Subject: FW: A/122/19/OUT - Land off Arundel Road, Angmering - Development Framework Plan

Please find attached the revised layout plan for outline planning application A/122/19/OUT - Land off Arundel Road, Angmering.

The Development Framework Plan shows the Site boundary, the means of access into the Site, the areas of retained and new landscaping and the location and extent of the proposed land uses, including the amount of built development.

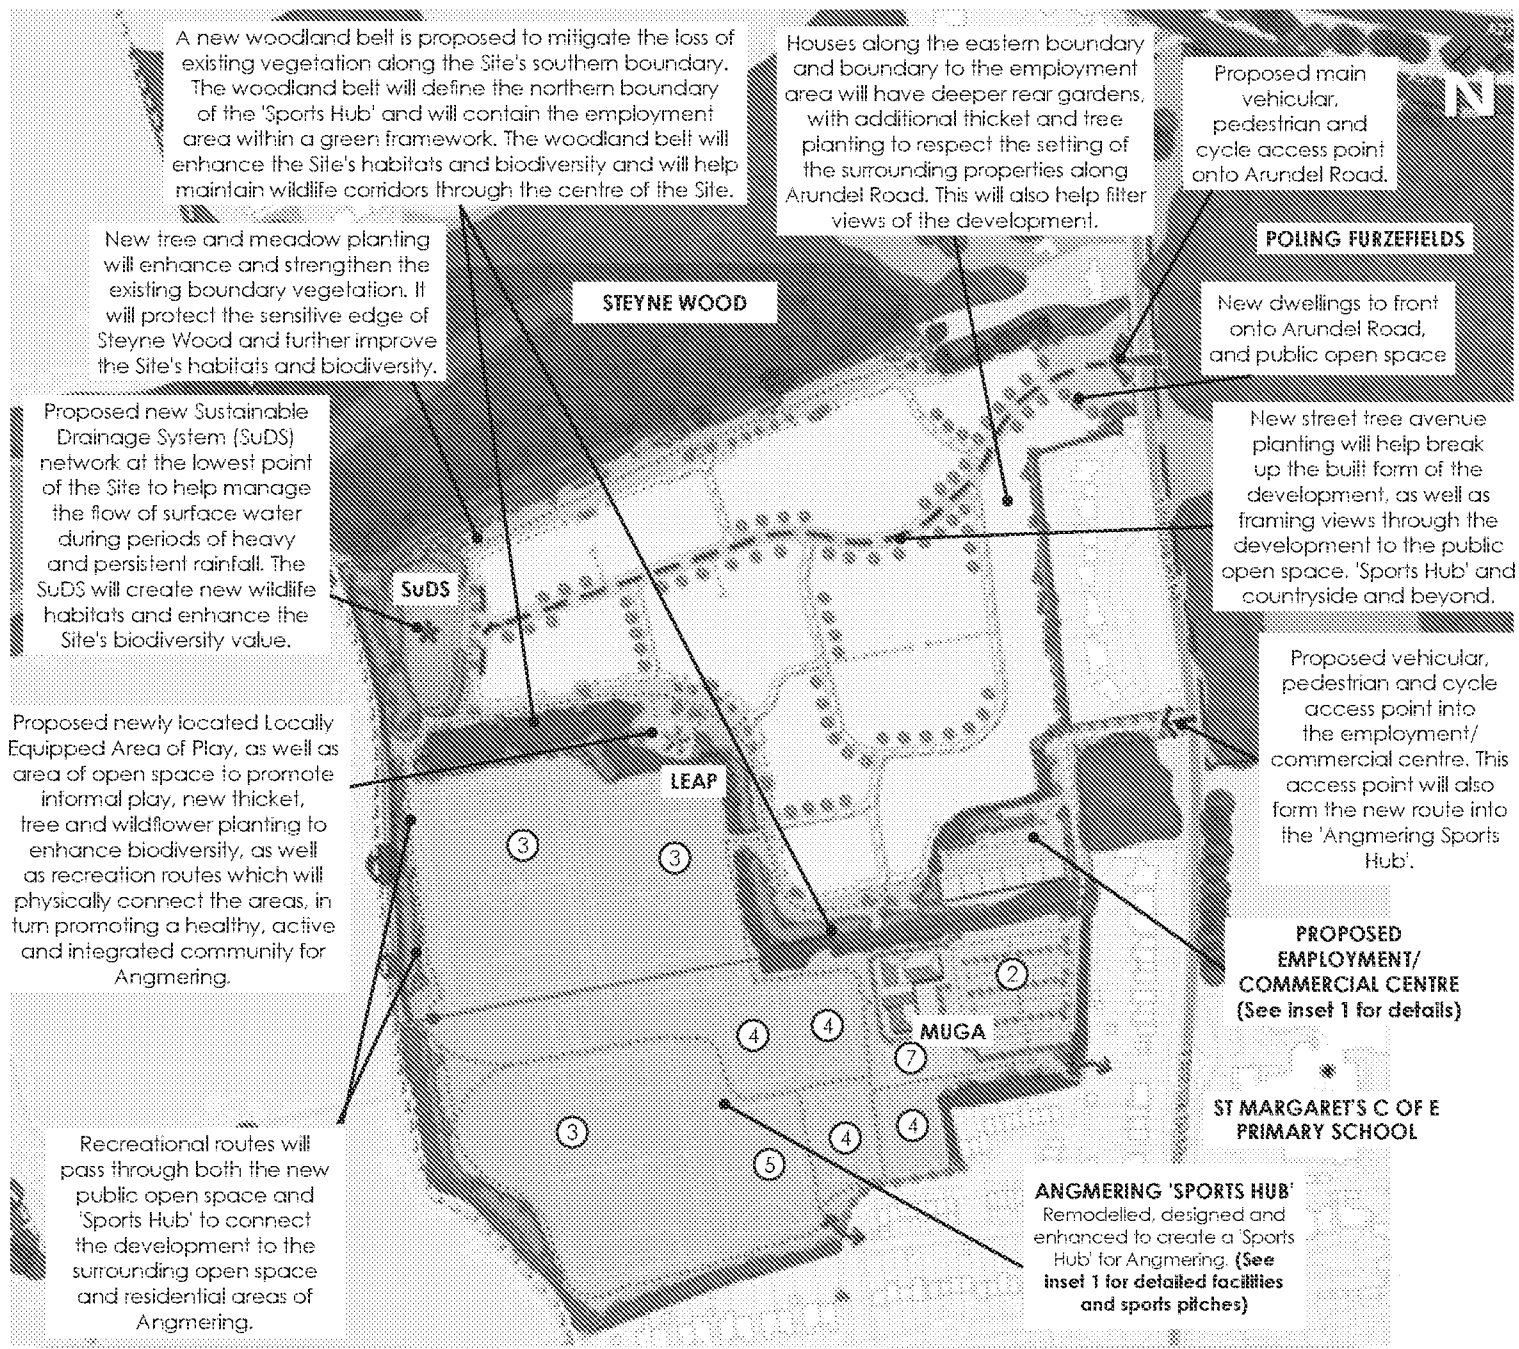
From a Greenspace view I am happy to see the revised location of the LAP now further within the site and away from the LEAP and entrance greenspace.

The cycle/footpath link onto the PRow, as my previous consultation comment is very important. Good to hear that the developer is keen to address this also, even though not possible in the north/west of the development because of third party boundary issues, but with the potential for negotiation as part of the Palmer Road Hub site development proposals.

The revised layout plan refers to the foot/cycleway being amended, but the SDNPA is seeking confirmation that there would be a connection with the PRoW that follows the western border of the site and/or a pedestrian/cycle route alongside Arundel Road. A connection with the PRoW along the western boundary would be achievable, but at the moment appears to be prevented by new hedgerow planting.

Thanks for sight of this latest revision. I note that it refers to the foot/cycleway being amended, but I'm afraid I haven't been able to identify how this differs from the previous revision (Rev D)! The key point I'd be seeking for any such amendments would be confirmation that there would be a connection with the PRoW that follows the western border of the site and/or a pedestrian/cycle route alongside Arundel Road. The former would seem very simple to provide, but at the moment appears to be prevented by new hedgerow planting.

Please find attached updated Development Framework Plan with LAP relocated.

The previous iteration of the DFP showed a footpath only. We agreed this would be shown as a footpath and cycleway and noted that it would link into the wider Public Right of Way network. We can't however form the final connection point onto the PRow as this point of connection falls outside our land ownership and in the Palmer Road recreation ground – the connection is reliant on the sports pitch/hub proposals being implemented and part of our land gifting. A footpath cannot connect from our Western boundary directly as there is an existing hedgerow that defines our legal boundary ownership, with a ditch in third-party ownership before the PRow can be reached. However, the £550,000 contribution towards a cycle route to Angmering village centre appears to address this concern directly.
